DECISION DELEGATED TO DEVELOPMENT MANAGER

Application No: H08-0504-20 **Applicant:** Mr T Mason
Proposal: Erection of Garage/Shed
Location: 2 Panton House Hedgefield Hurn Gosberton
Terminal Date: 14th September 2020

ANGLE IRON FRAME MADE  
FROM 30<sup>mm</sup> X 50<sup>mm</sup> ANGLE  
COVERED WITH GREY  
CLADDING

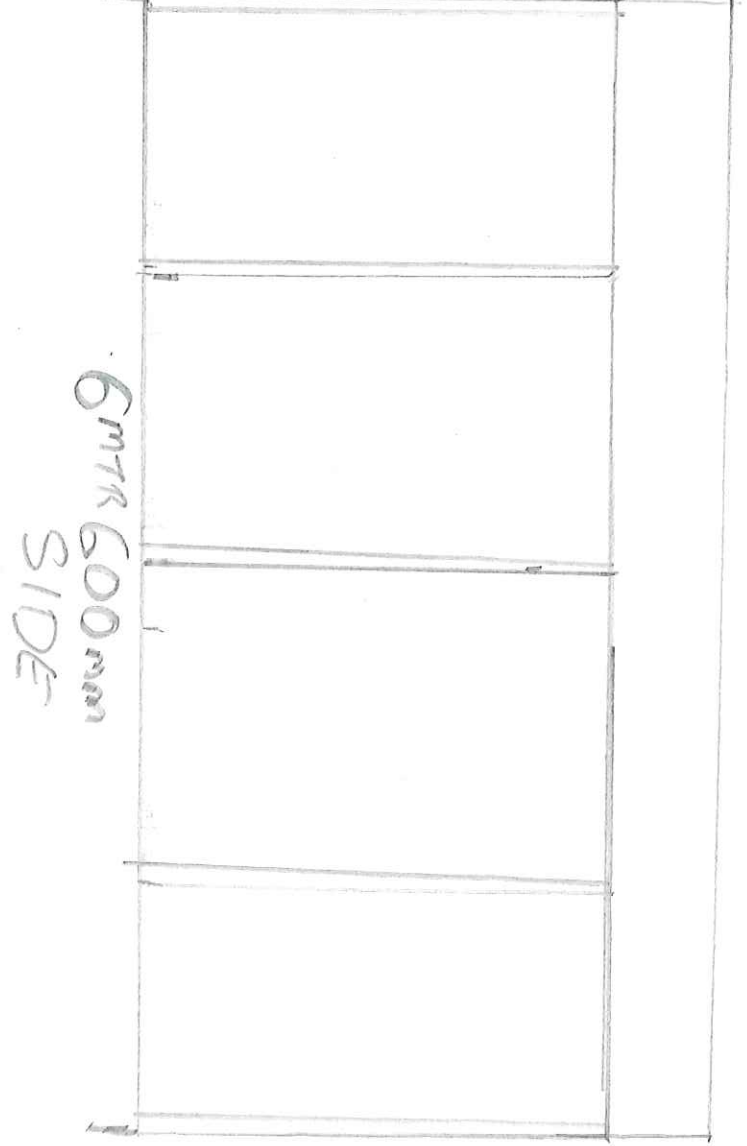
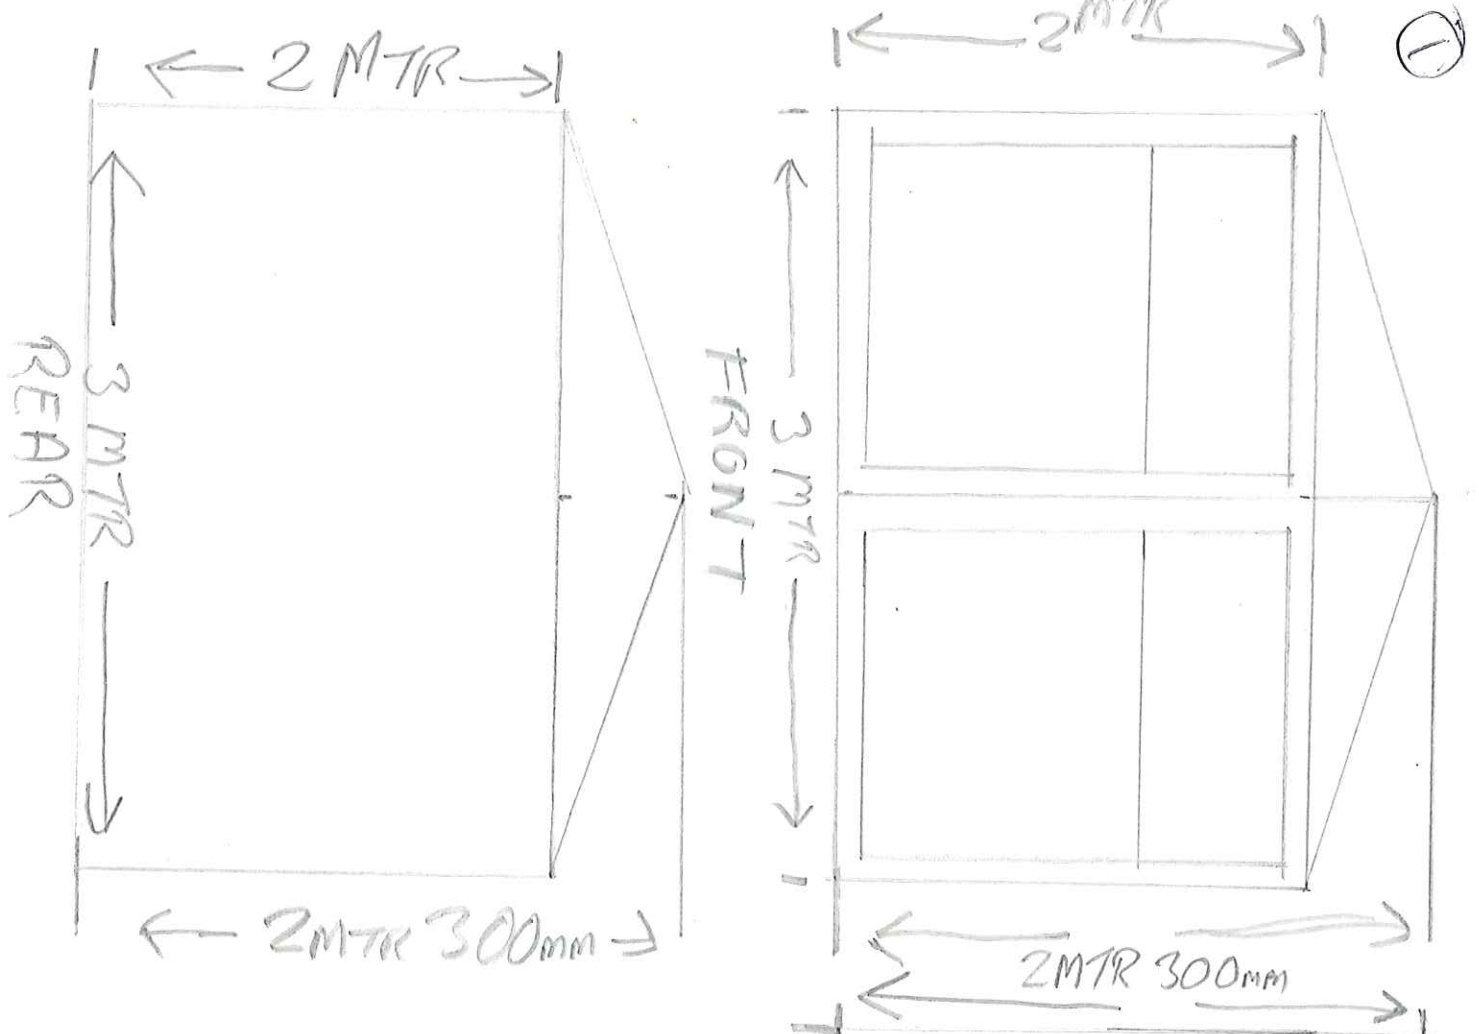
The Local Planning Authority considers this application to present an unacceptable impact upon the character of the curtilage and setting of the Grade II Listed Panton House. The proposed structure is not in any way appropriate to the curtilage of a Grade II Listed, early C19 property. The use of a steel frame and corrugated grey steel cladding is entirely inappropriate to the setting of such a property, giving a stark and industrial looking addition to the plot which would be at odds with the C18th rural architecture of the host property. The Local Planning Authority seeks to use the controls that are available in order to ensure wherever possible that development preserves or enhances the character and appearance of the District's Listed Buildings. The installation of a simple steel framed industrial style structure, particularly one clad using entirely modern materials, would have an unacceptably harmful impact. The alien appearance of modern corrugated steel in a listed curtilage would undermine the character and appearance of the host property.

Furthermore, the proposed location of the structure, to the side of the property would be completely and clearly visible from the public realm, obviously impacting upon public appreciation of the setting of the building.
